Report of the Head of Development Management and Building Control

Address: 35 COPPERFIELD AVENUE HILLINGDON

Development: Use of the land to site a mobile home for ancillary use to the main dwellinghouse (Application for a Certificate of Lawful Development for a Proposed Development)

LBH Ref Nos: 22078/APP/2025/1108

PROPOSED
JOINT
LINE

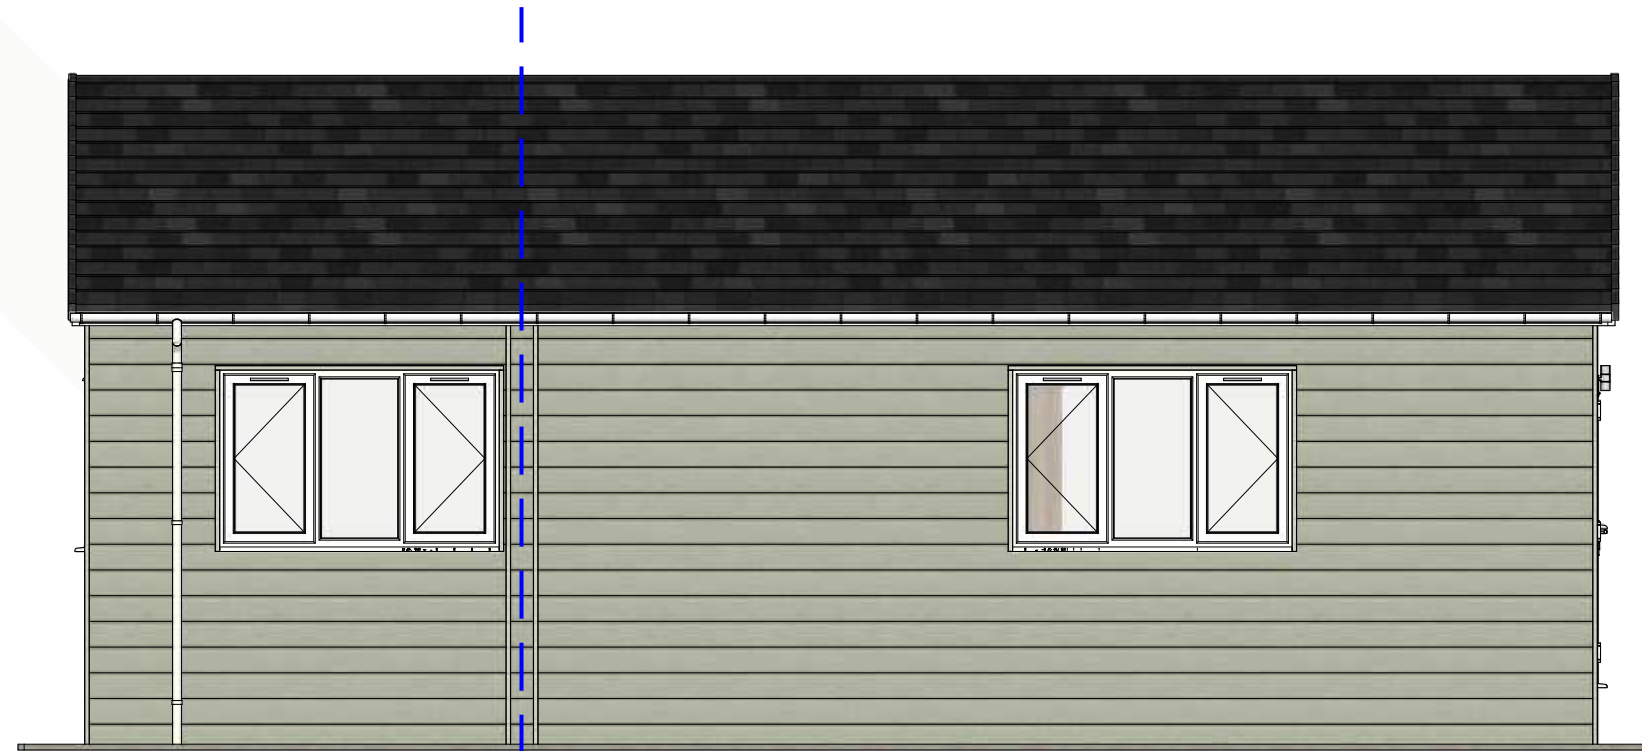
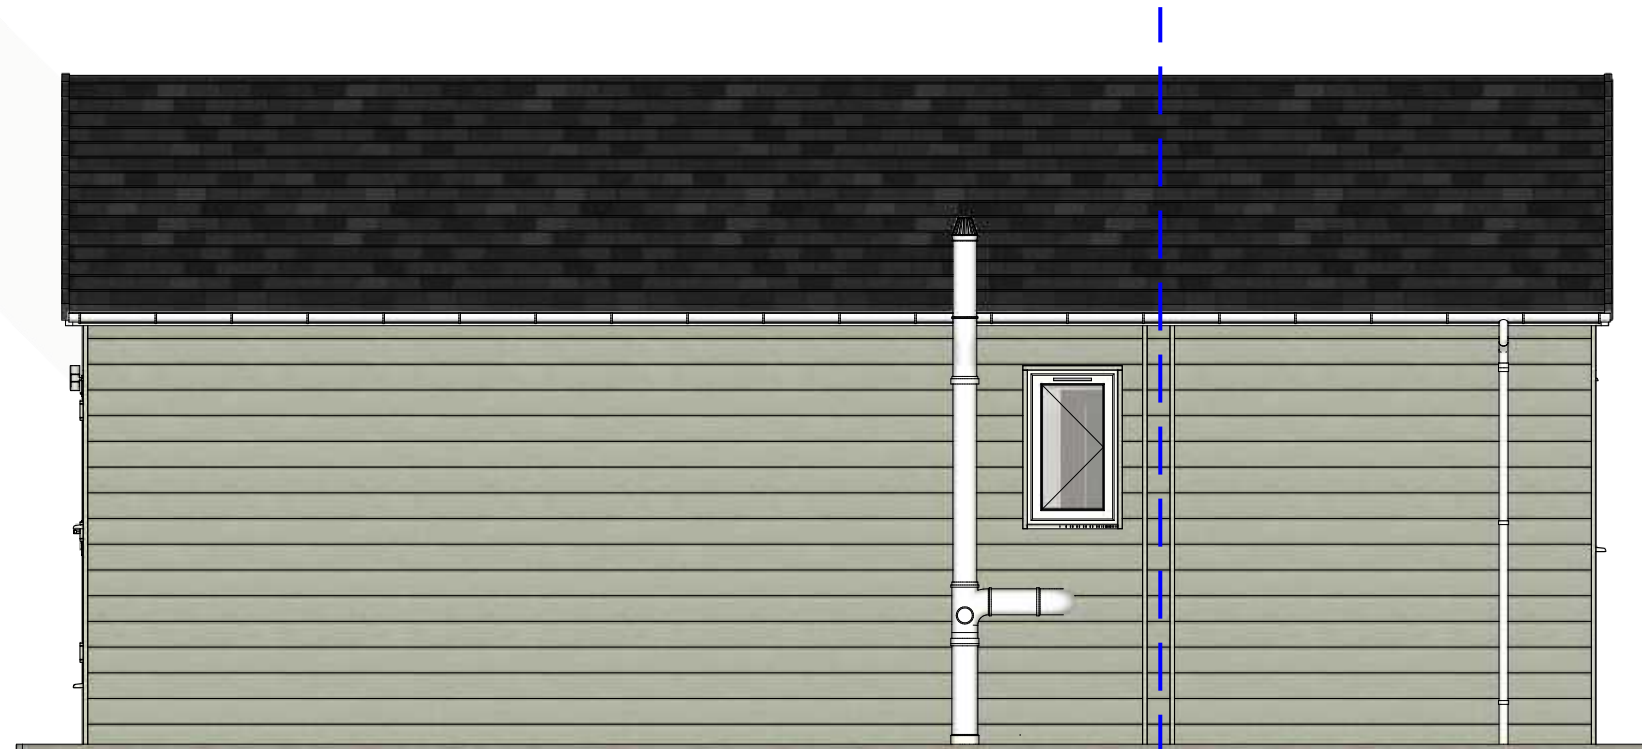
The planning statement confirms that In alignment with these specifications, the proposed mobile home will be assembled on-site, with two distinguishable sections, and the final act of assembly will involve the bolting of these two parts together. Drawing ref: 2254.03.25D.10.07, included in the application, illustrates the two sections that will be separately constructed on the application site and subsequently joined together on the same site as the 'final act of assembly' (construction methodology provided in Appendix L).

Considering the above, officers consider that the proposal meets all three tests outlined in Section 13 of the Caravan Sites Act 1968 and its amendment in October 2006. Consequently, the proposal should be considered a caravan, and, as such, does not constitute operational development.
